Subject: RE: Planning Consultation on: BR/63/22/PL

Please see Private Sector Housing comments below which remain the same from the comments previously provided in respect of BR/65/22/L, with the exception of one additional comment under the 'General' section.

Application No: BR/63/22/PL
Registered: 23rd May 2022
Site Address: Salisbury House The Steyne Bognor Regis PO21 1TX
Grid Reference: 493270 98859
Description of Works: Change of use of 5 No self-contained flats for adults with learning difficulties to 5 No self-contained flats and formation of 5 No further flats from HMO rooms, garage and office, repairs and decoration of external surfaces, minor alterations to elevation facing Sadler Street, change one window facing rear courtyard to French doors & apply obscure film to 2 windows in courtyard area.

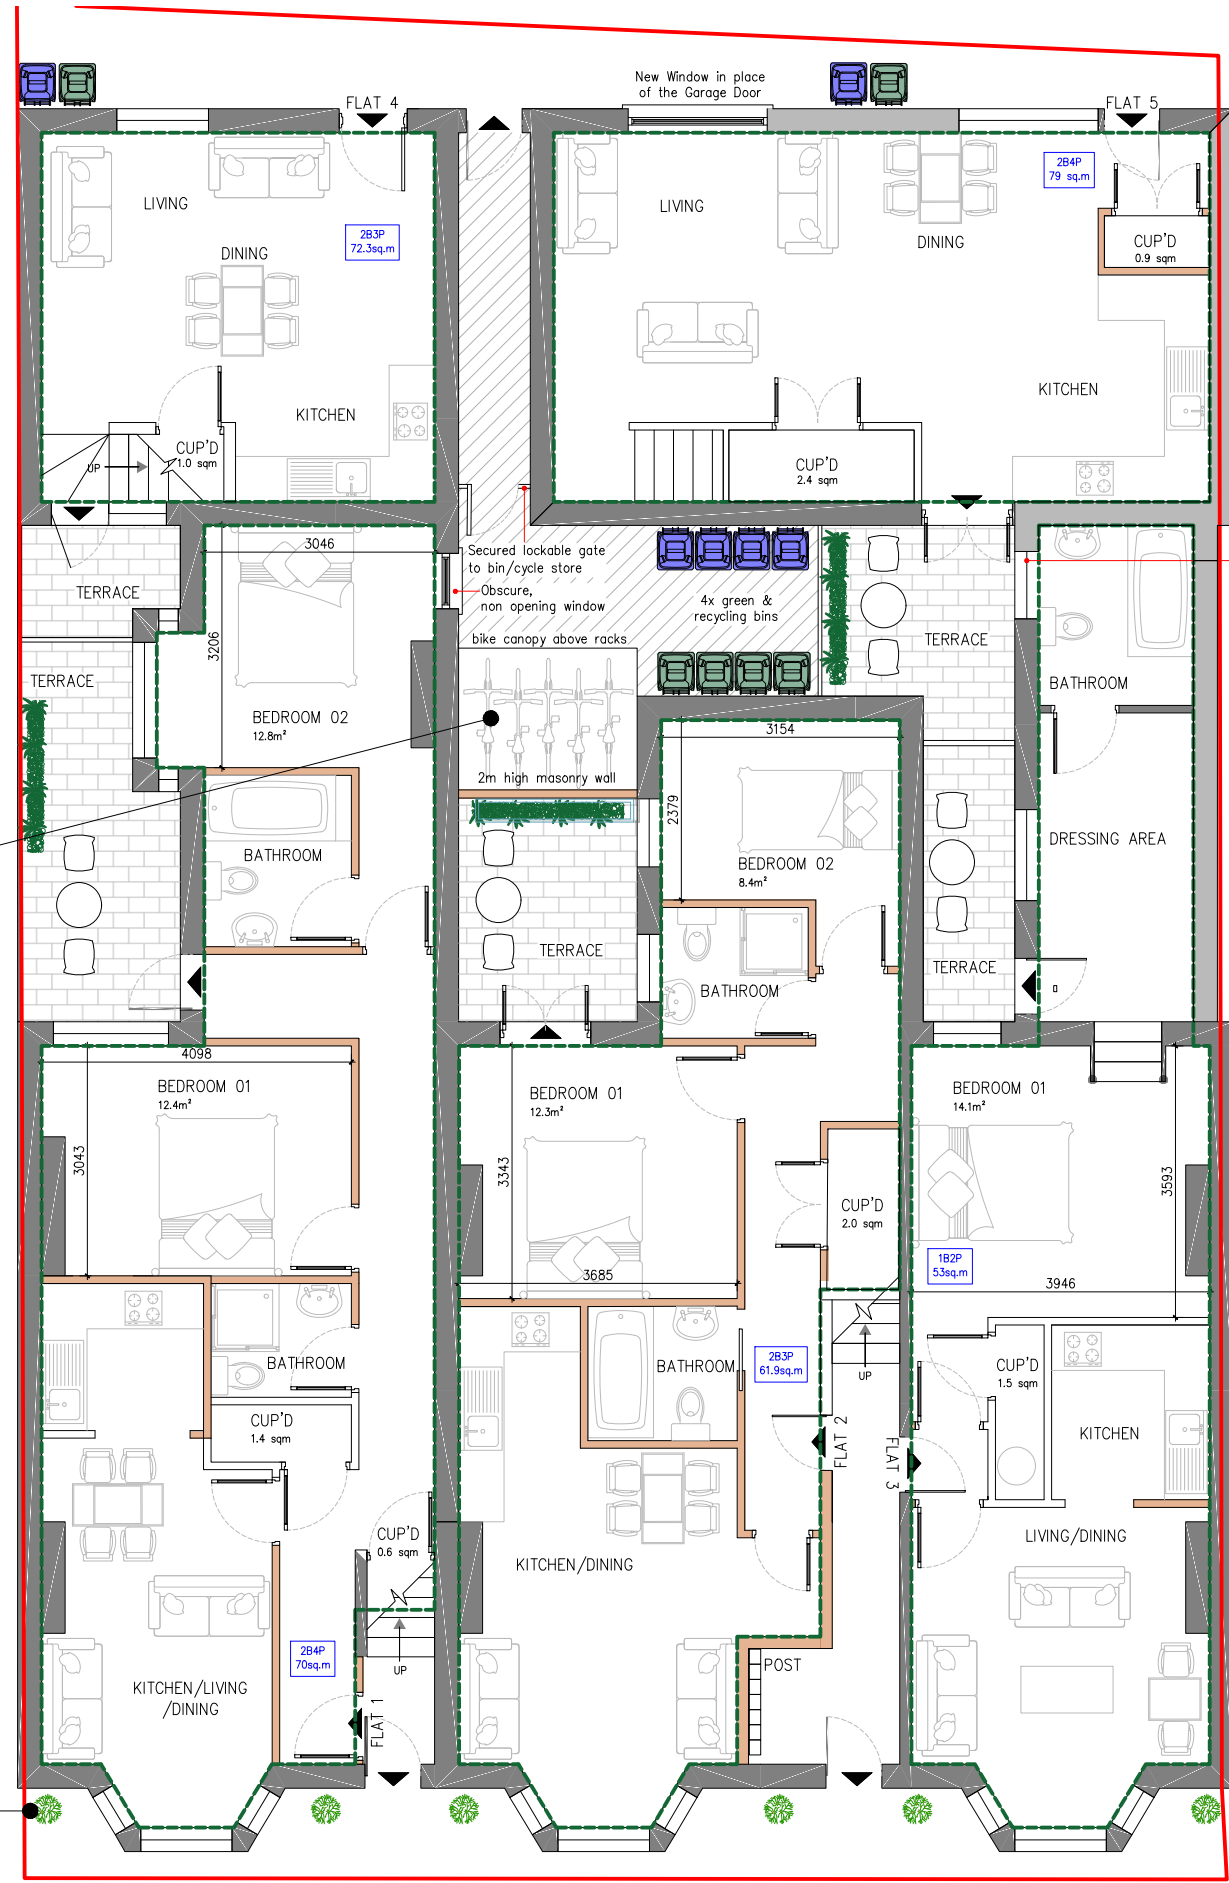
- Kitchens should have adequate mechanical ventilation
- Mechanical extraction should be provided to all bathrooms/shower rooms/ensuites
- The double doors within Flat 2 bedroom 1 provide the only means of ventilation within the bedroom. Consideration should be given to installing a separate openable window light to enable the ventilation to be better controlled. For example, enabling the occupier to have a window open during the night and during prolonged periods of rain

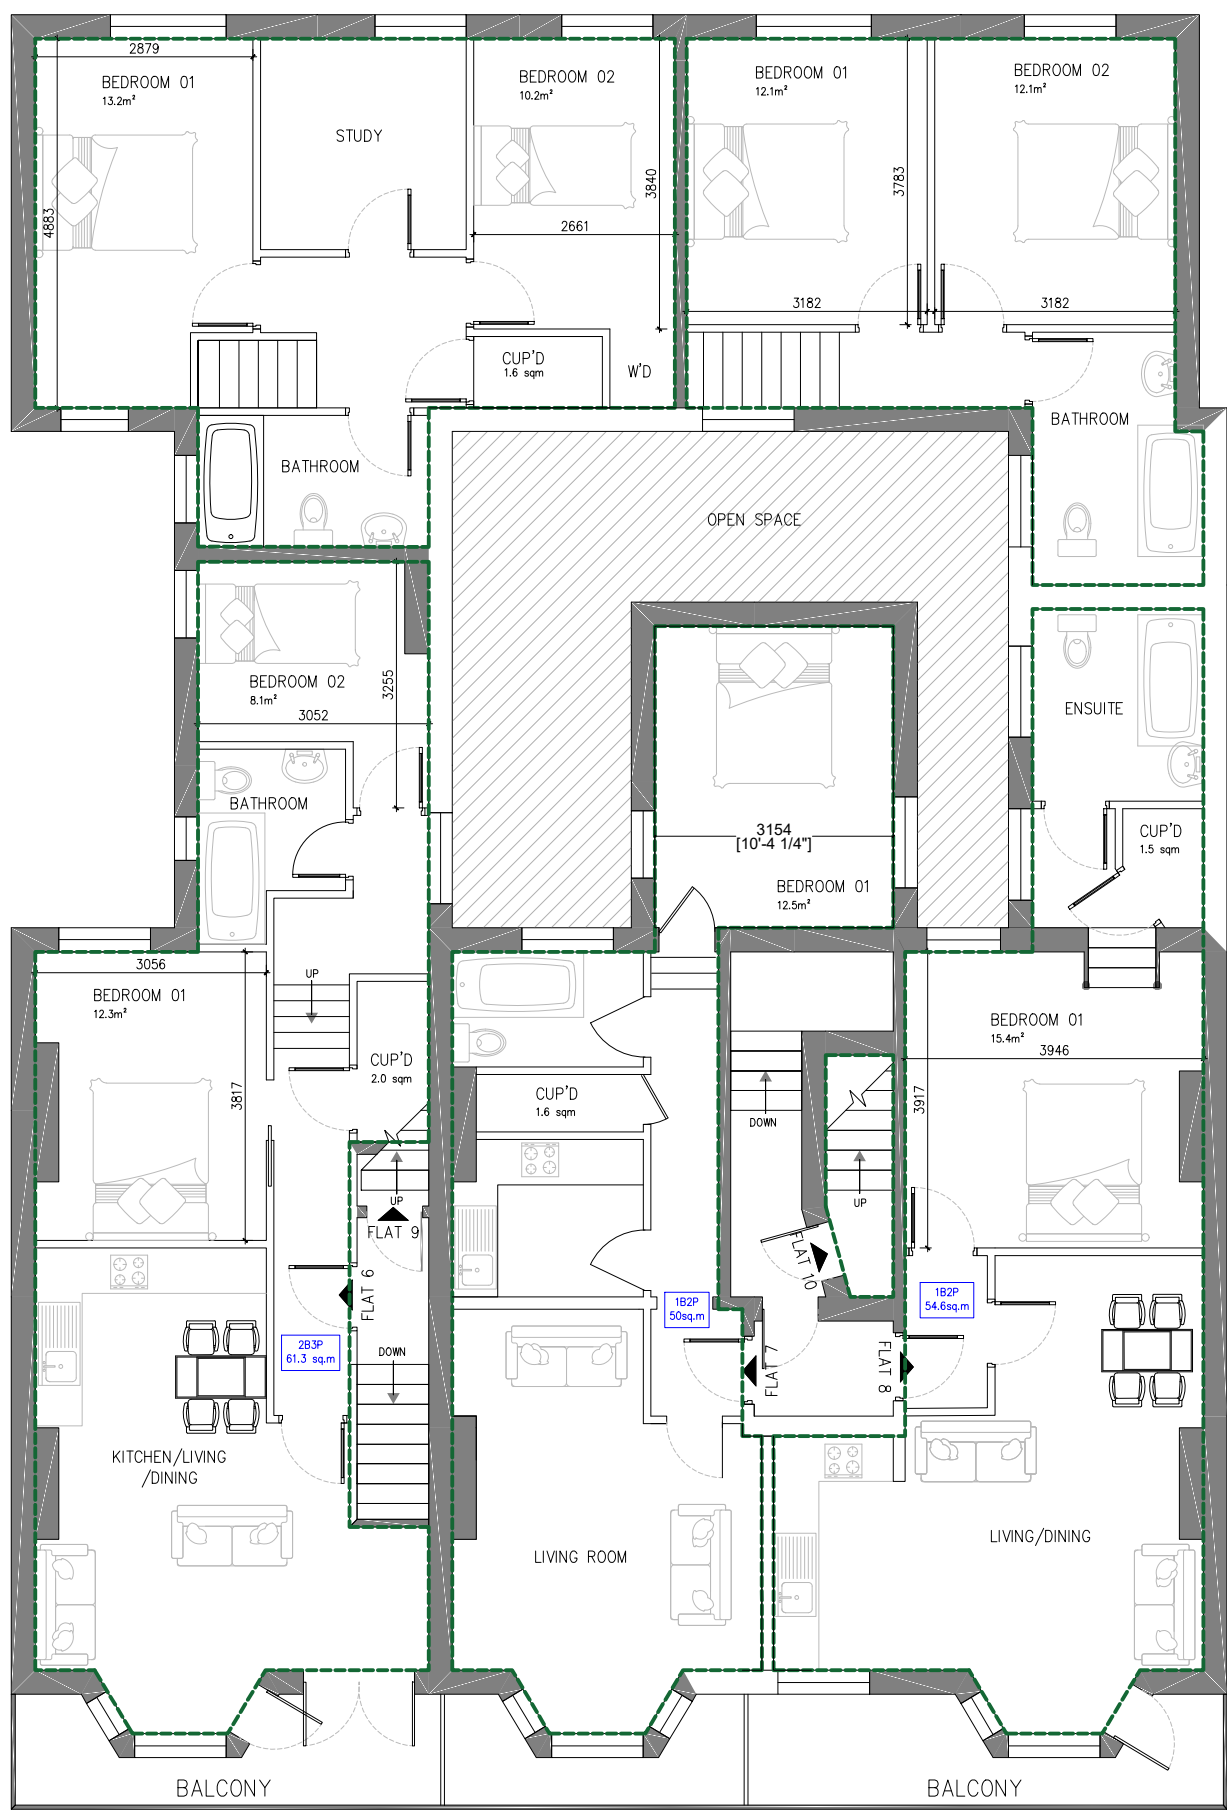
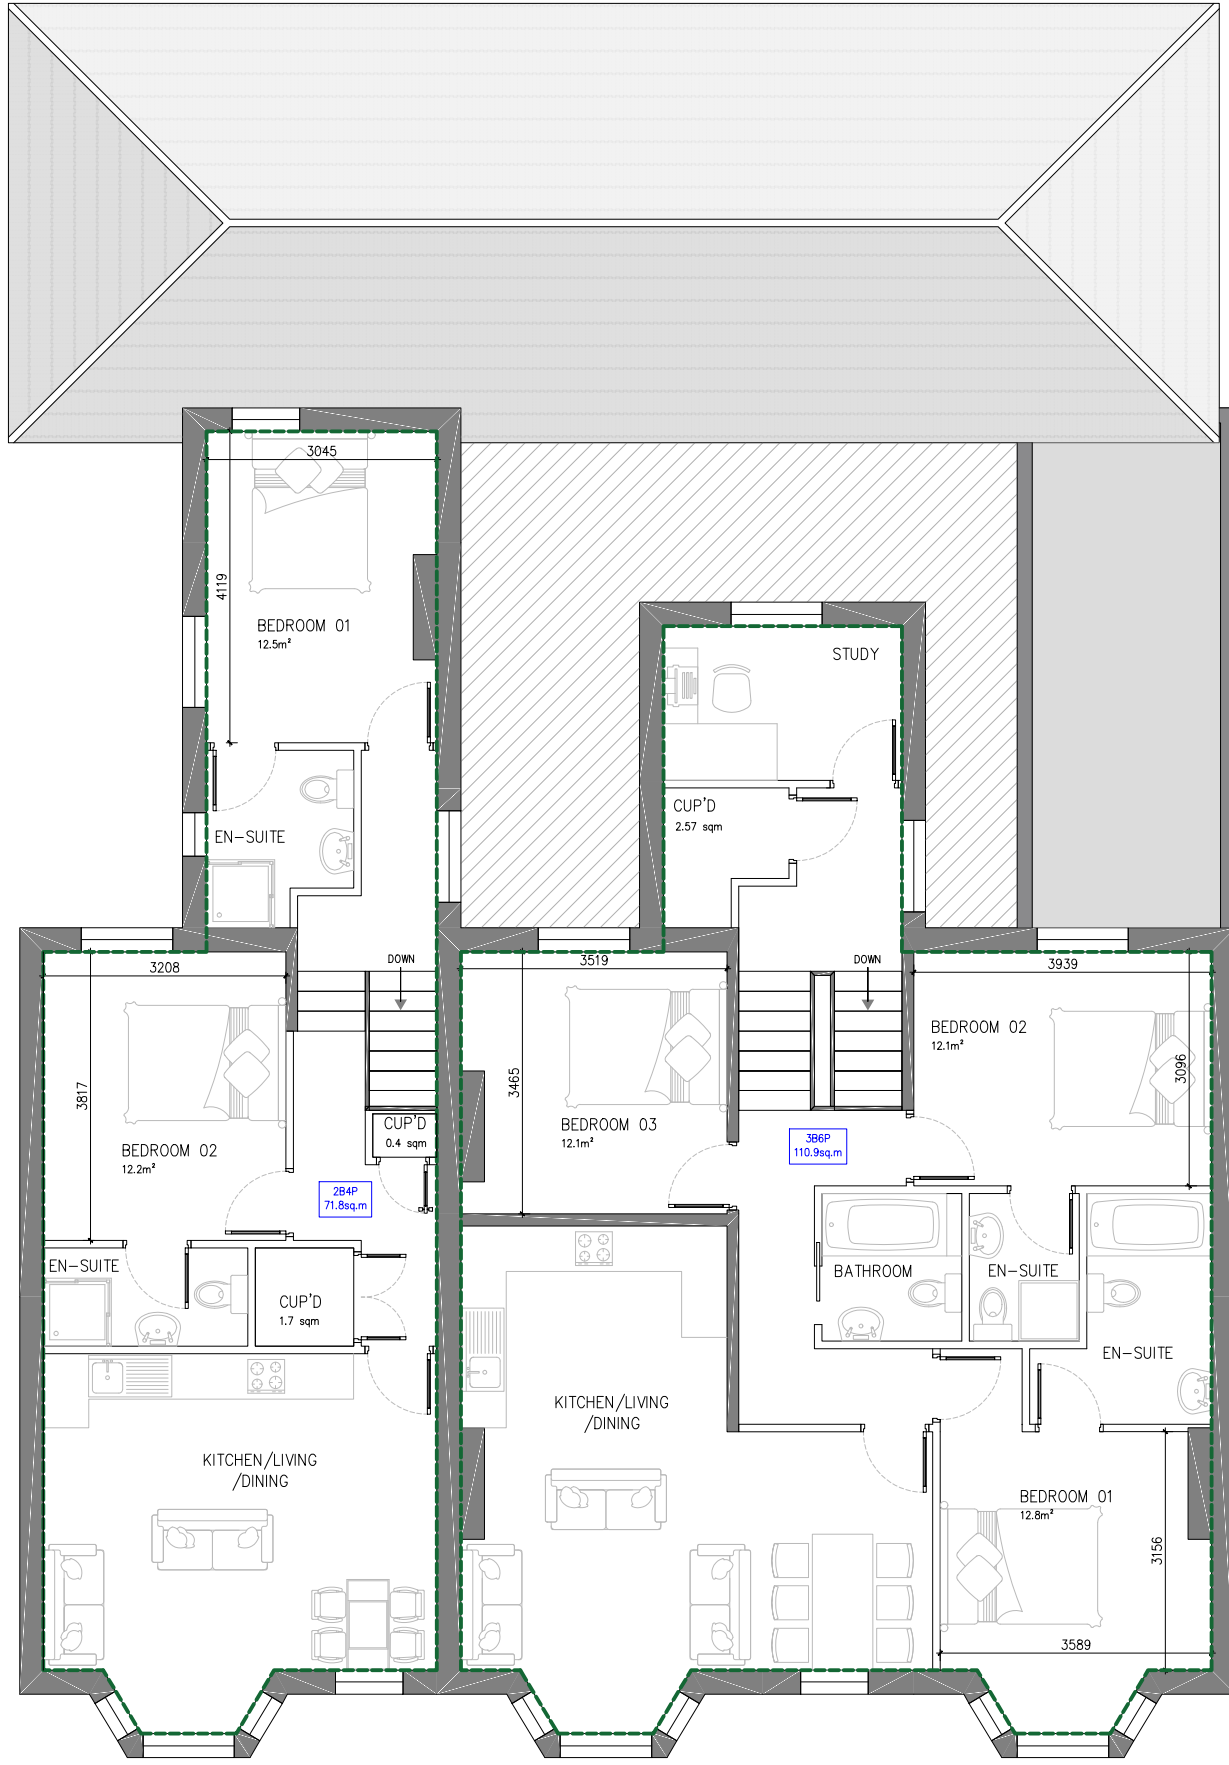
- A room where the only escape route is through another room is termed an "inner room" and poses a risk to its occupiers if a fire starts unnoticed in the outer room. As egress from flats 4 & 5 is via the open plan living room/kitchen, an escape window should be installed to bedrooms 1 & 2 within both flats. An escape window should only be installed if the following criteria can be met:

- They serve rooms whose floor level is no more than 4.5m from the ground;
 - Every room served by the escape window has access to it without entering another habitable room;

- If it is necessary to pass through the escape route to reach the window, consideration should be had to the travel distance involved;
 - Occupiers are able-bodied individuals who can reasonably be expected to exit via the window unaided;

- There is no basement well or other encumbrance beneath the window such as railings or a conservatory;
 - The escape window is openable from the inside without the need for a key and the ground below is level and free of obstructions; and

- The window should lead to a place of ultimate safety. However, if this leads into a courtyard or back garden where there is no exit, it should be at least as deep as the building is high
- The internal escape routes should provide 30 minutes fire resistance, including the provision of 30-minute fire resisting and self-closing fire doors (FD30S) to each flat entrance that opens onto the escape route
- A mixed Grade A, LD2 and Grade D1, LD3 fire system should be maintained and installed
